WEST SUSSEX COUNTY COUNCIL CONSULTATION

TO:	Arun District Council - FAO:M Tomalova
FROM:	WSCC - Highways Authority
DATE:	1 December 2021
LOCATION:	107 Felpham Way Bognor Regis PO22 8QB
SUBJECT:	FP/252/21/DOC Approval of details reserved by condition imposed under ref FP/52/21/PL relating to Condition Nos 3 - bin storage, 7 - electric vehicle charging and 8 - covered & secure cycle parking.
RECOMMENDATION:	No Objection

Drawing
Site Plan As Proposed

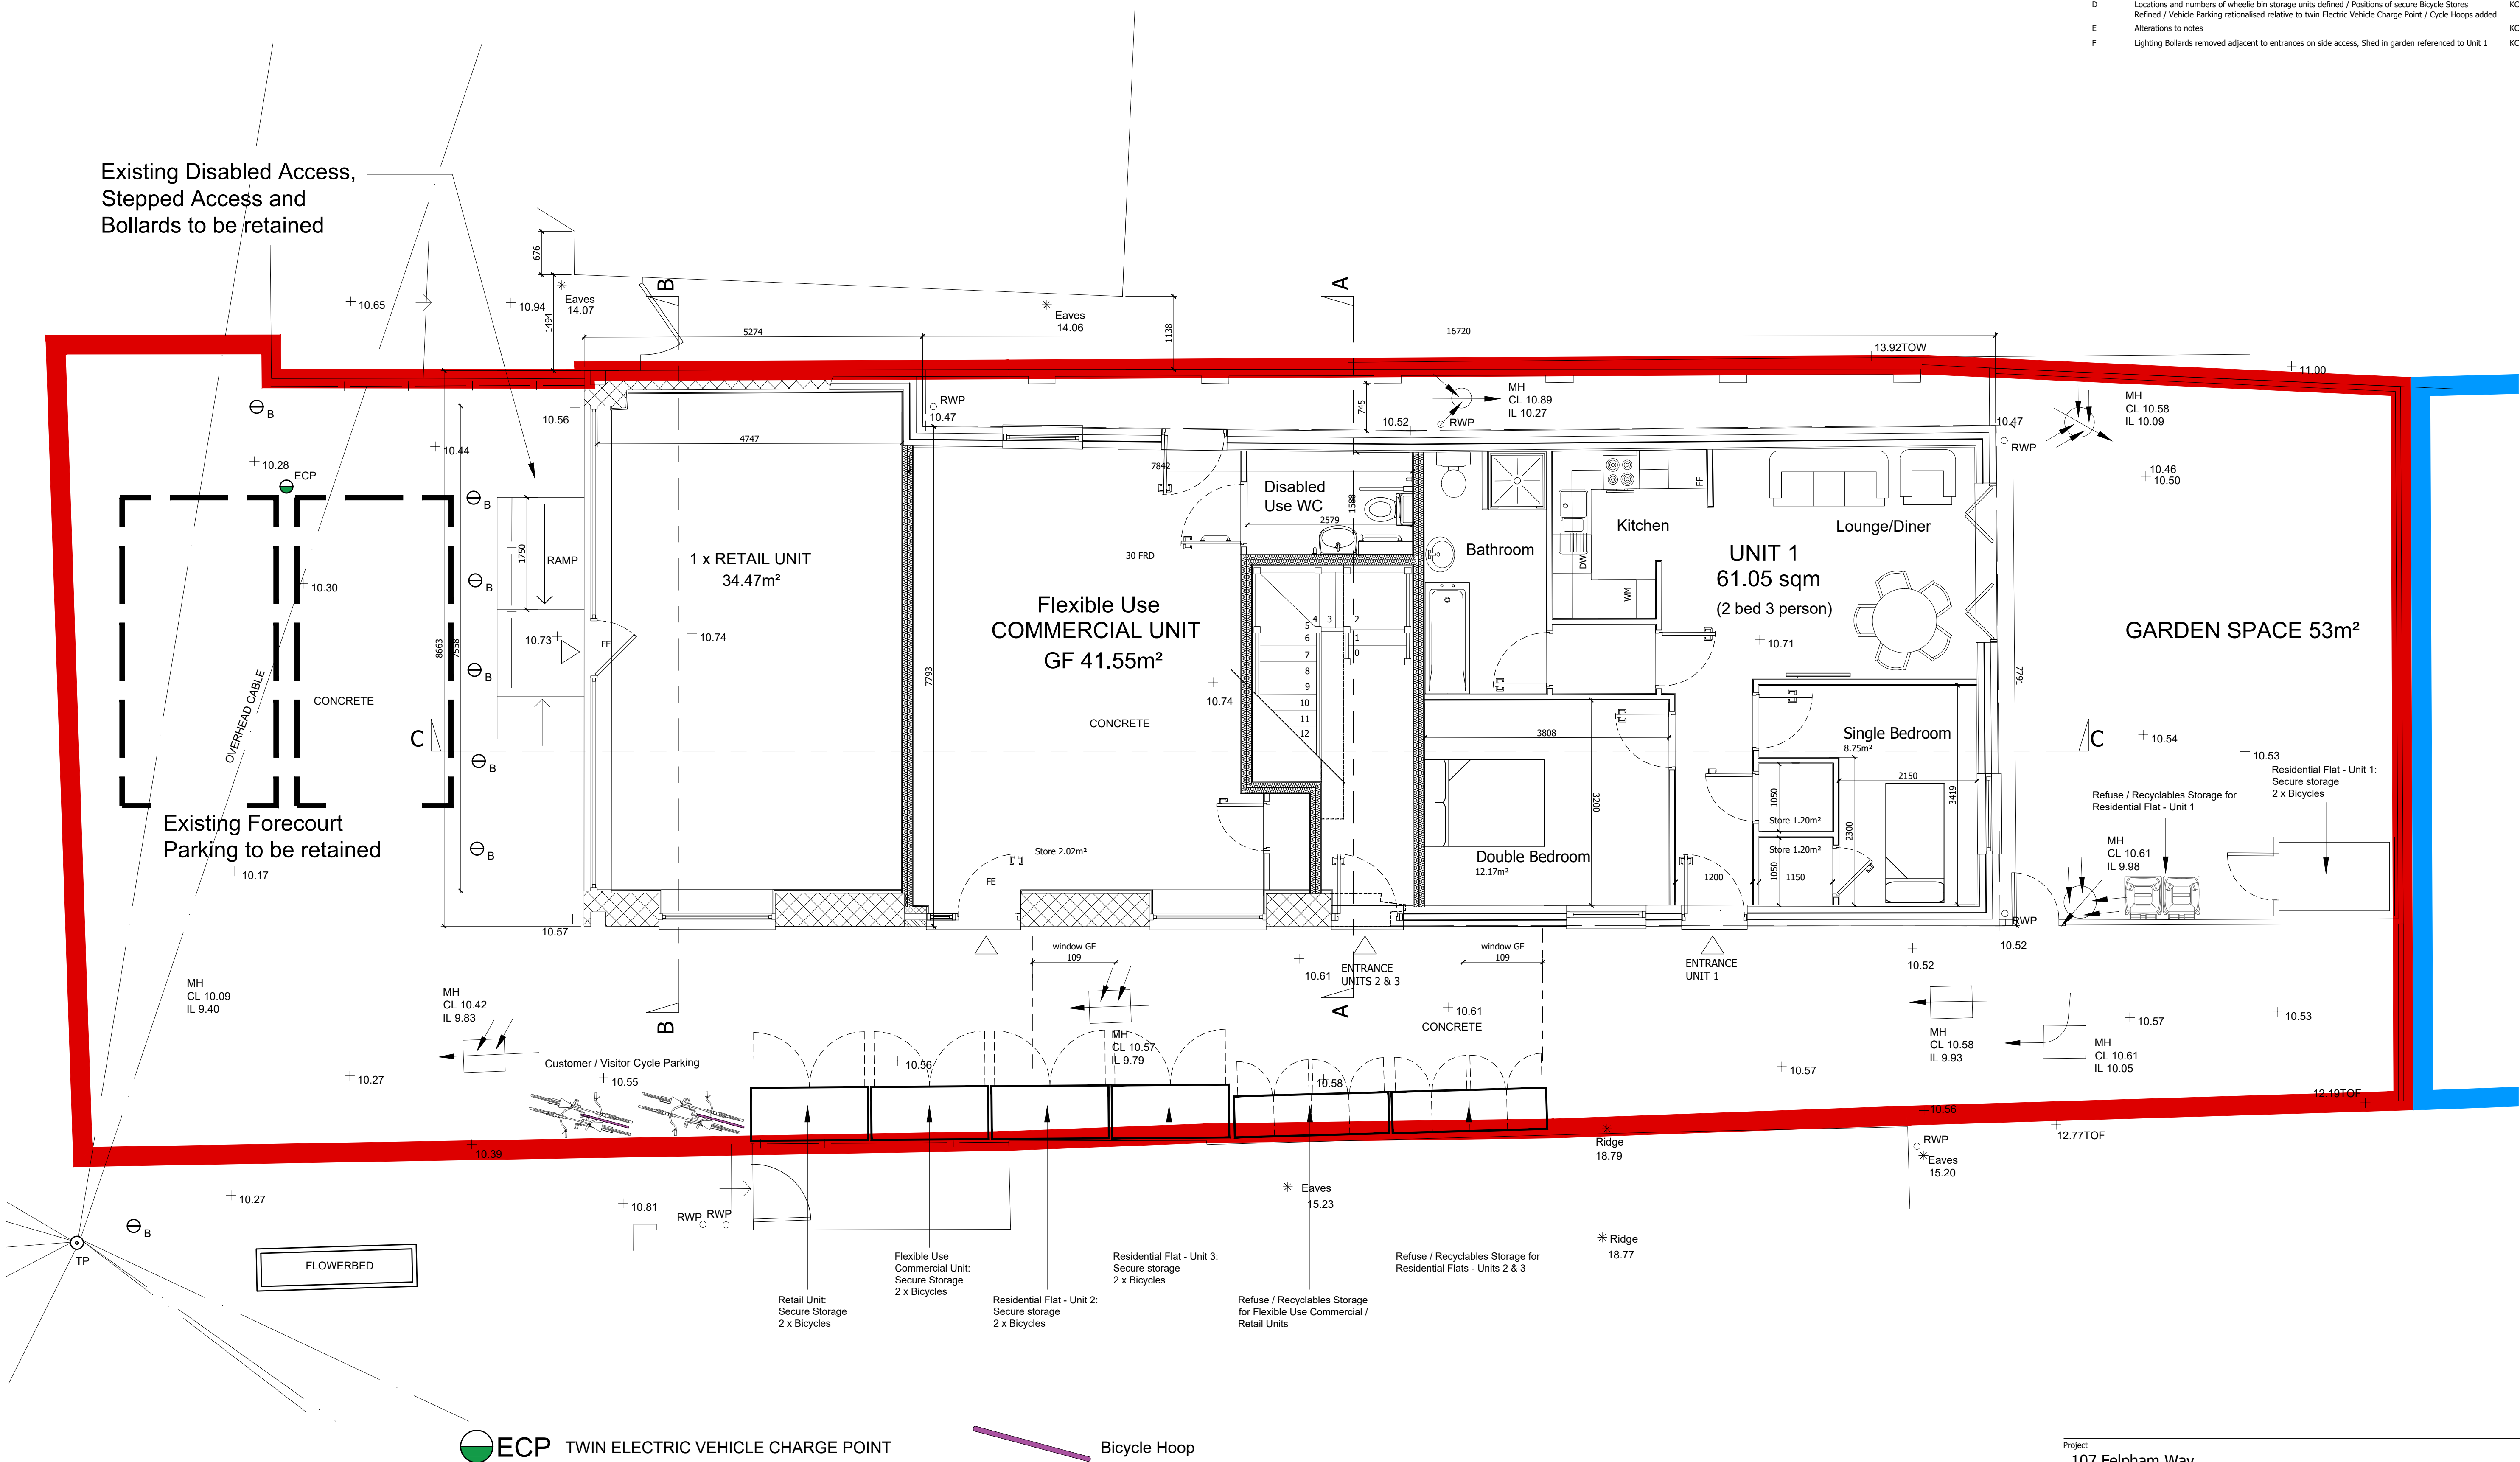
condition 7 - EV parking - a charging point is shown for the 2 x car parking spaces

the plans and details pertaining to conditions 7 and 8 are acceptable from the highways point of view.

Project: Standard Products	Title: Sheffield Stand Fixing Details	
Date Drawn: 13/02/2020		
Draftsperson: M.Stokes		
 Third Angle Projection	Scale: 1:8 @ ISO A3	
	DWG No: 1.0	Revision: 00

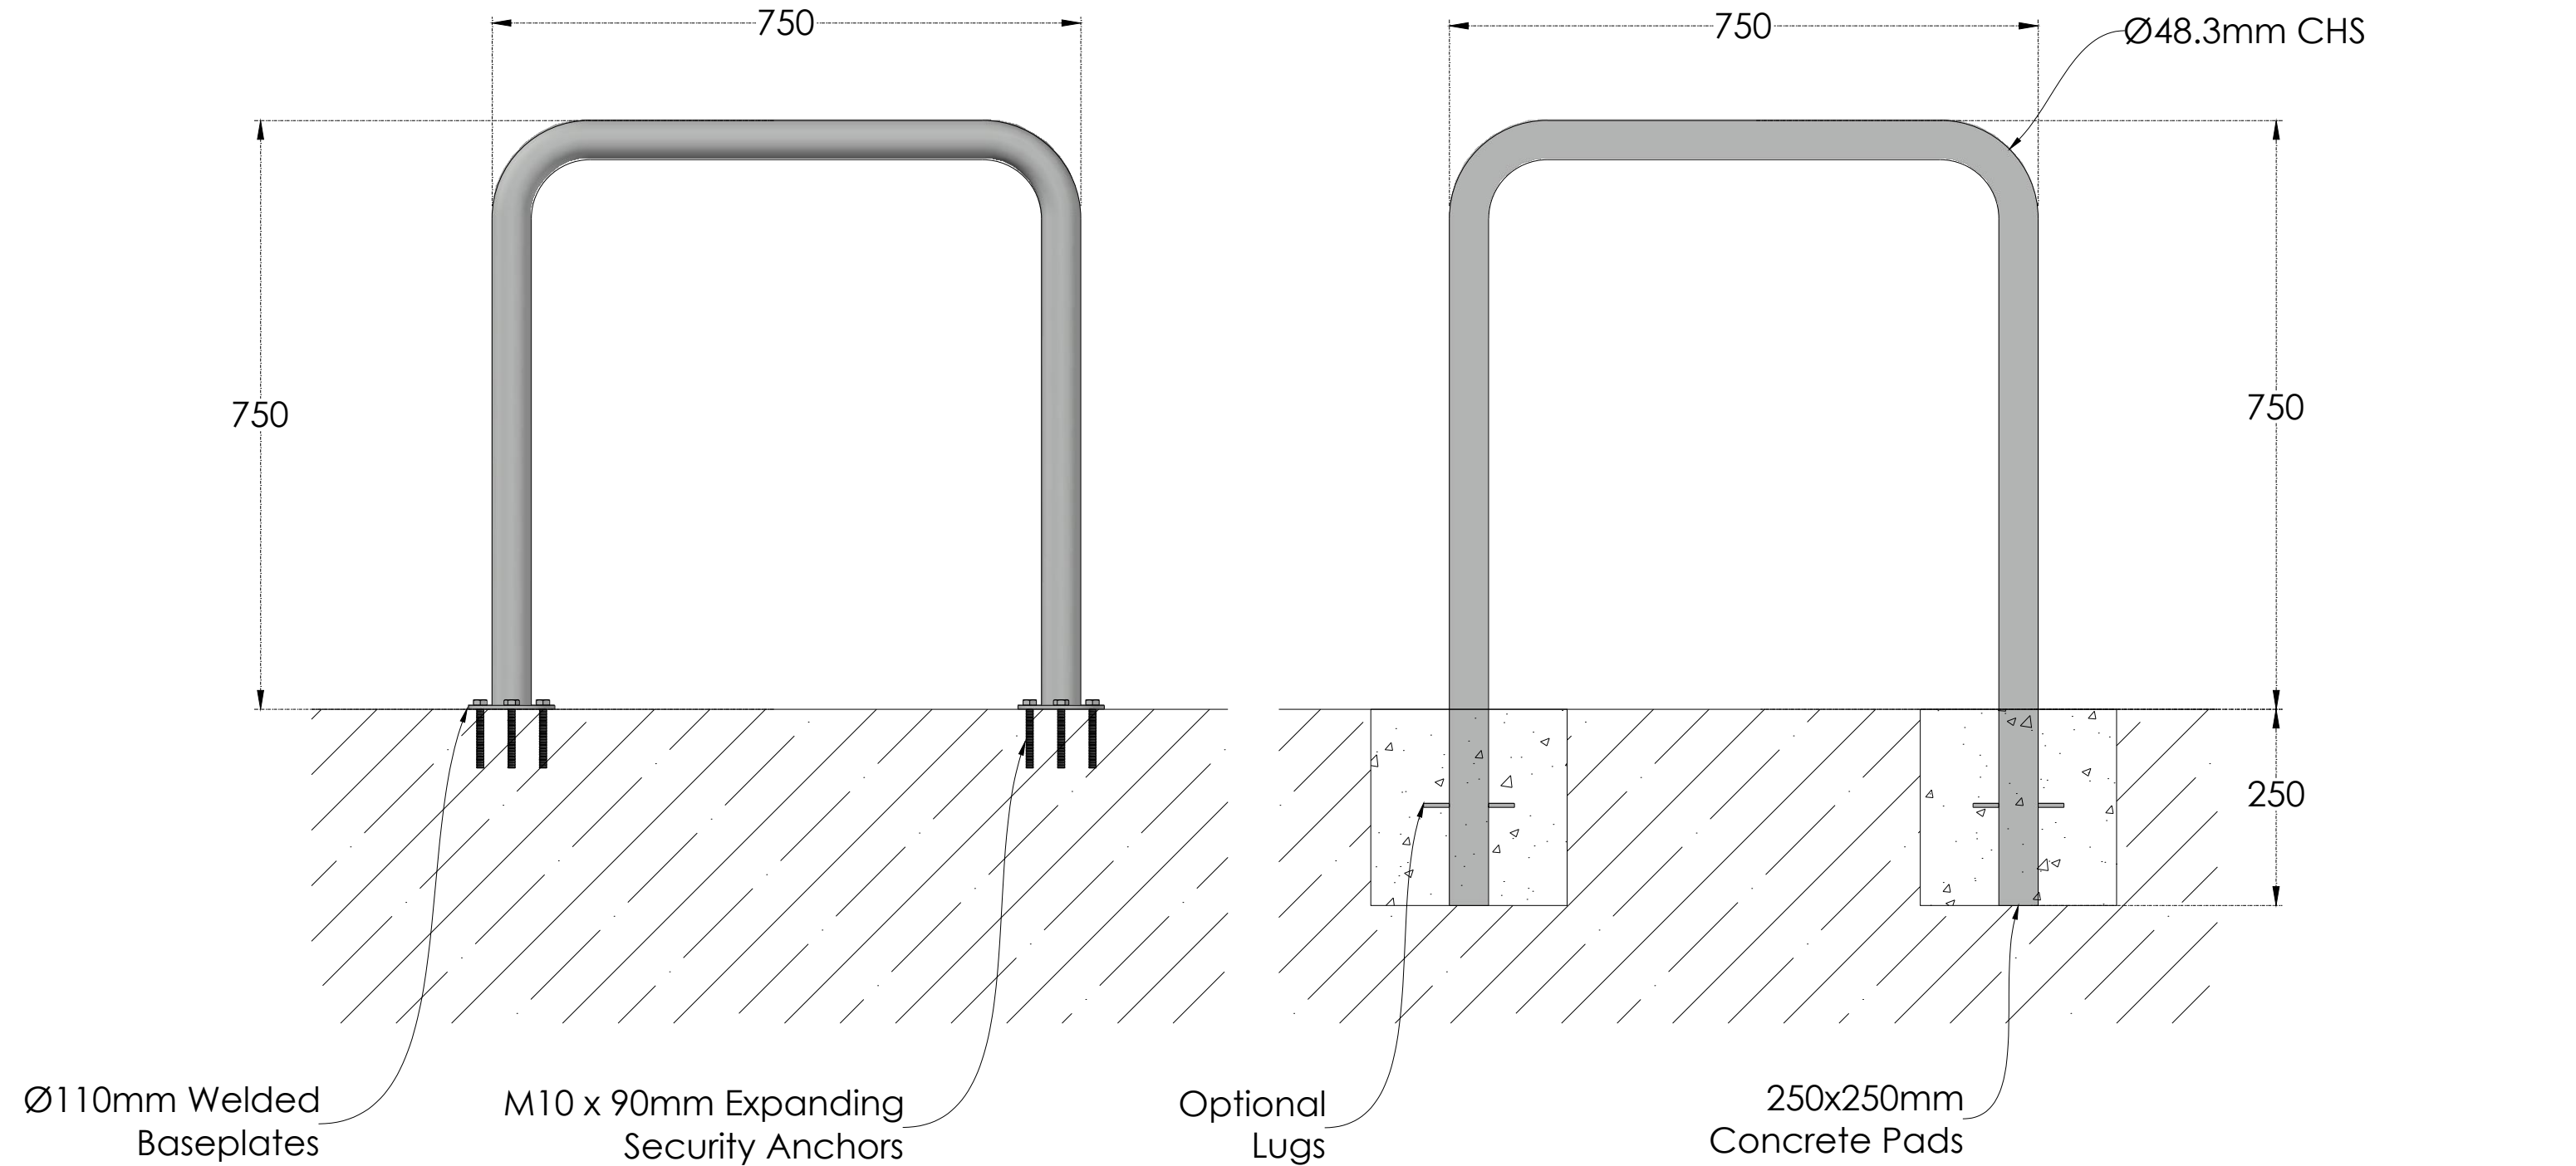
condition 8 - cycle parking - sufficient sheffield stand facility is shown for the commercial use and private shed for the flats
